Recommendation Report for Planning Permission for Works or Extension to a Dwelling

REF NO: EP/101/21/HH

LOCATION: 35 Roundstone Crescent
East Preston
BN16 1DG

PROPOSAL: Erection of single storey rear, part two storey side and front porch extension

Project: Proposed extension; 35 Roundstone Crescent, East Preston BN16 1DG	
Drawing: Plans and elevations as proposed	
For: Mr. P. Windsor & Ms. A. Finch	
Drawn: PKS	Date: June 2021
Scales: 1:100 1:200	No: 2743/01/02
To scale when printed on A3

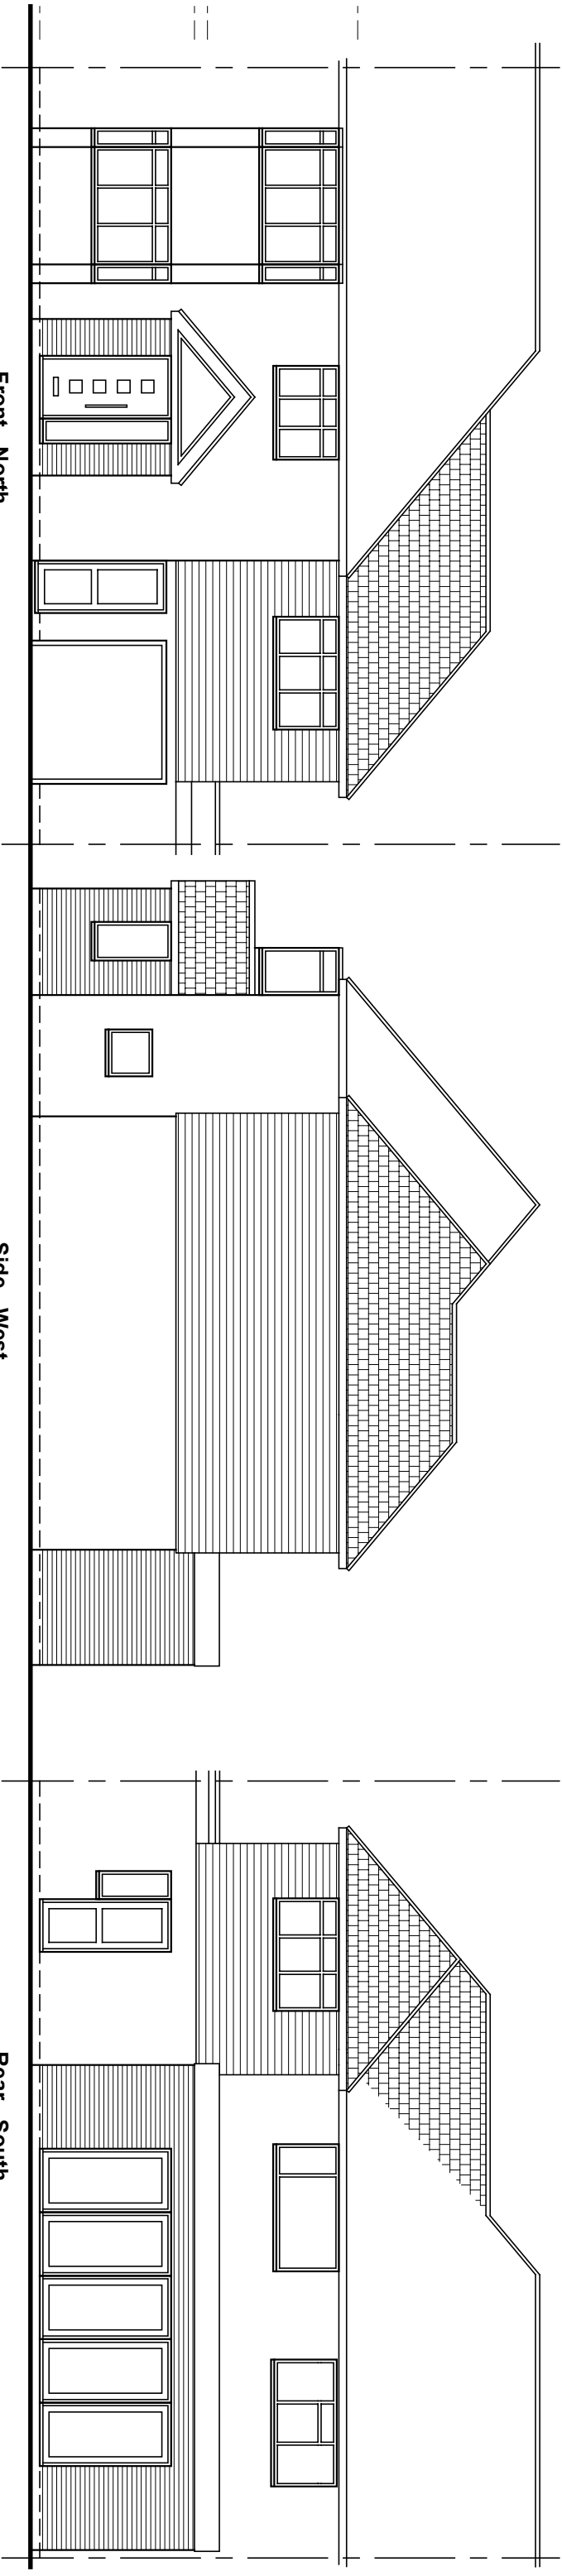
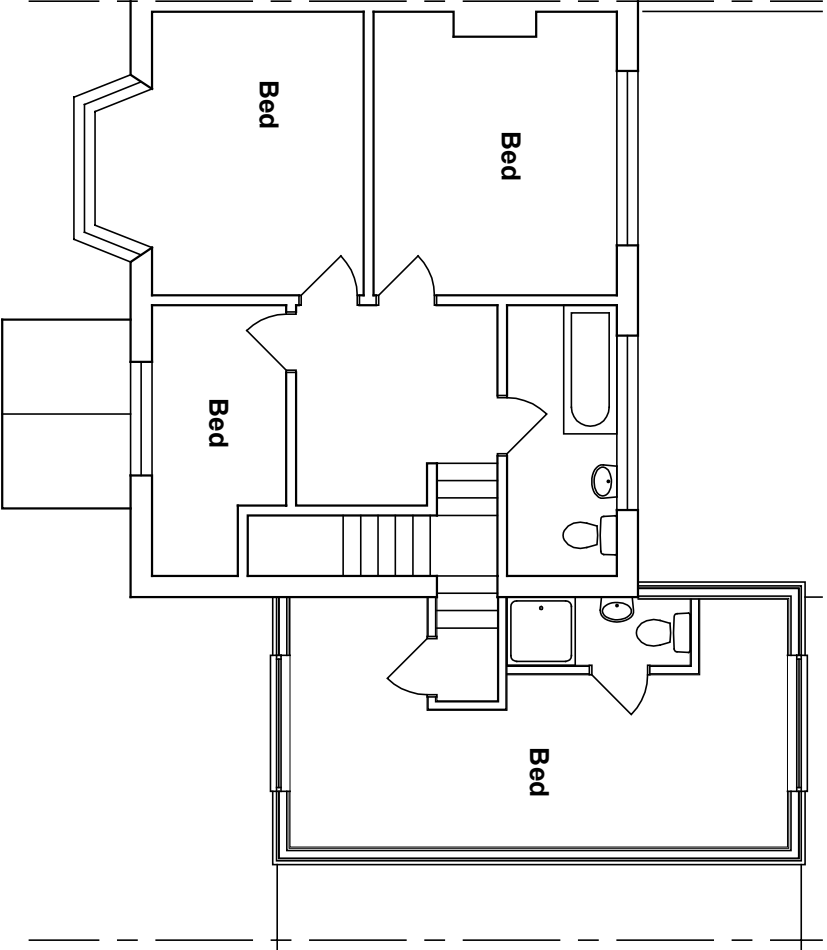
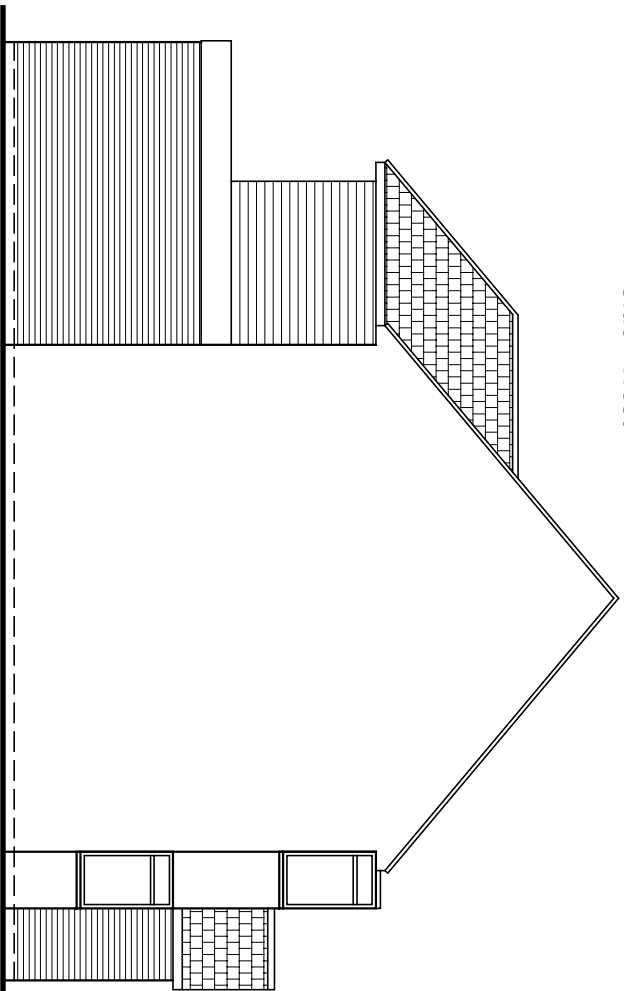
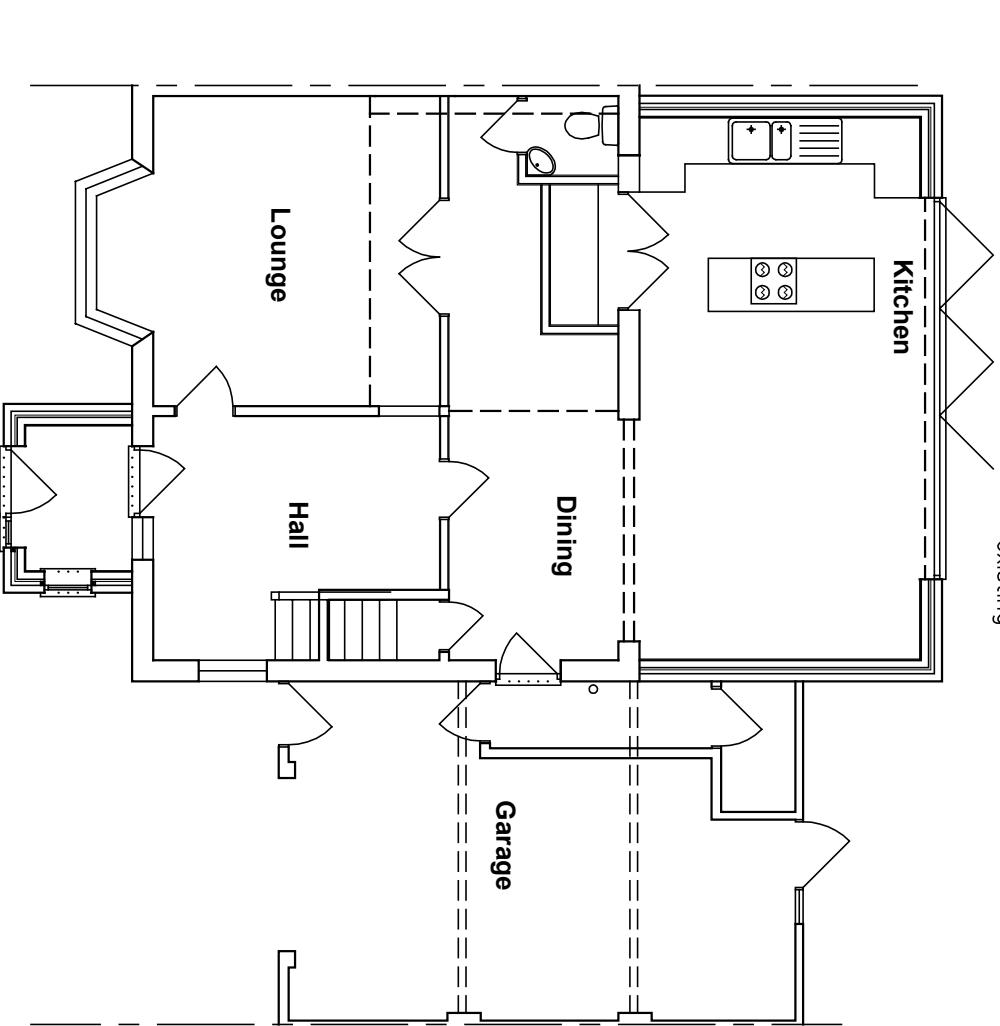
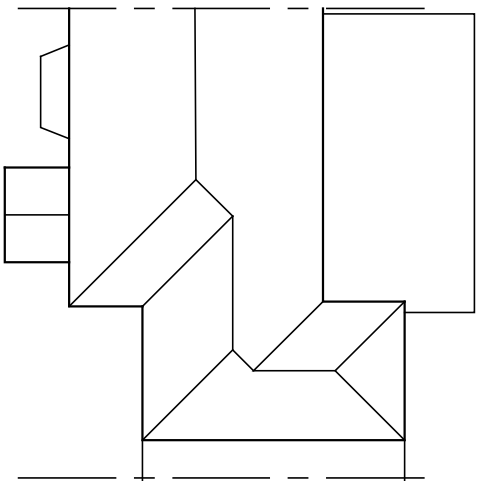
The ridge line of the proposed first floor side extension will be approximately 800mm lower than the main ridge height and it will be set back from the front elevation by 1.9m having the affect of making the addition subservient to the host dwelling.

It will be constructed of materials which match those currently found on site and with an eaves line to match and is therefore considered visually sympathetic to the dwelling and the surrounding streetscape. Additionally, extending above an existing structure is considered an effective use of the plot, in line with design guidance.

The rear extension is equally subservient due to its scale as a ground floor extension and is not visible from the street.

It is considered that the first-floor extension will not overbear or overshadow neighbouring properties. It will be set away from its nearest boundary to the east by 1m, in line with guidance, at which point at ground floor garage abuts a neighbouring garage.

When considering the 45-degree rule the first-floor extension accords with guidance in that it will be built no further forward of the rear building line of the neighbour to the east. Similarly, the rear extension will be built with its rear elevation protruding no further than the (nearest) neighbours to the west, who have also extended their property across the rear.

In terms of overlooking the proposed fenestration will either face towards the front or rear private amenity space of the dwelling and as such no additional views, other than those already achievable will be obtained.

Project:	
Proposed extension; 35 Roundstone Crescent, East Preston BN16 1DG	
Drawing:	
Proposed first floor	
For:	
Mr. P. Windsor & Ms. A. Finch	
Drawn:	Date:
PKS	June 2021
Scales:	No:
1:50	2743/01/04
To scale when printed on A3

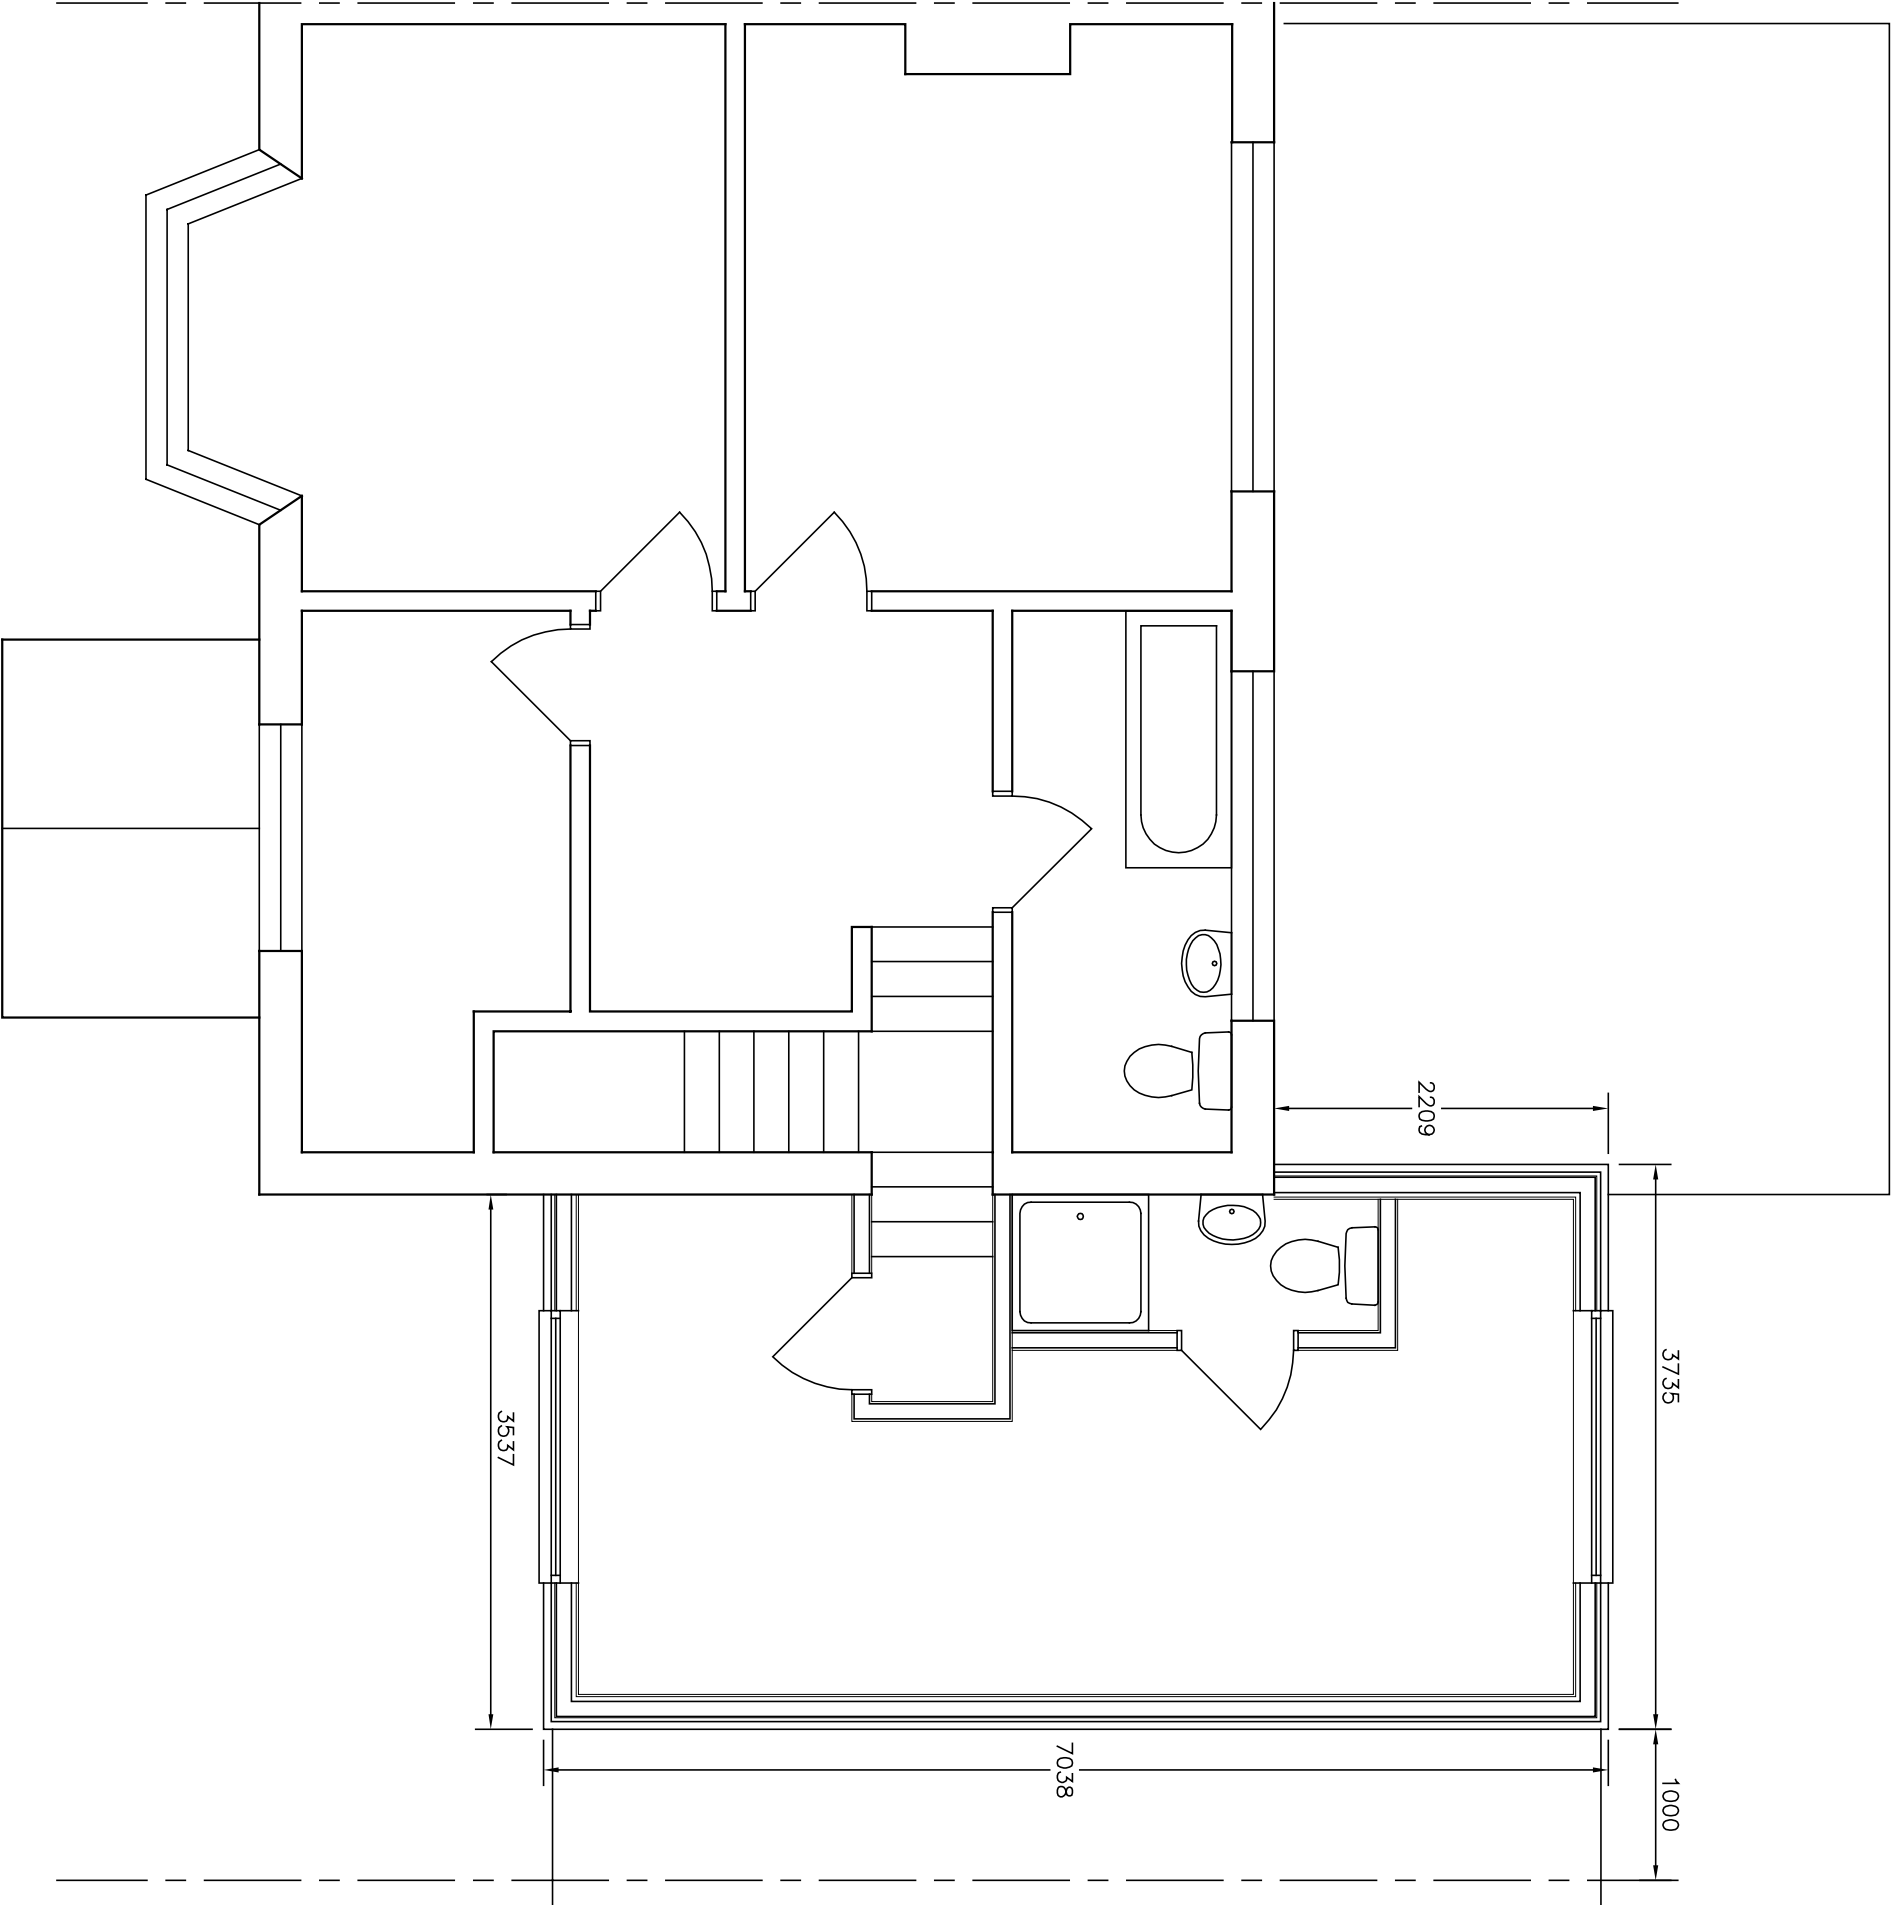
The existing space about the buildings in this location is good and it is not thought that the spatial character will be compromised further to the works taking place especially as the first-floor addition has been designed to be set away from the shared boundary in accordance with design guidance.
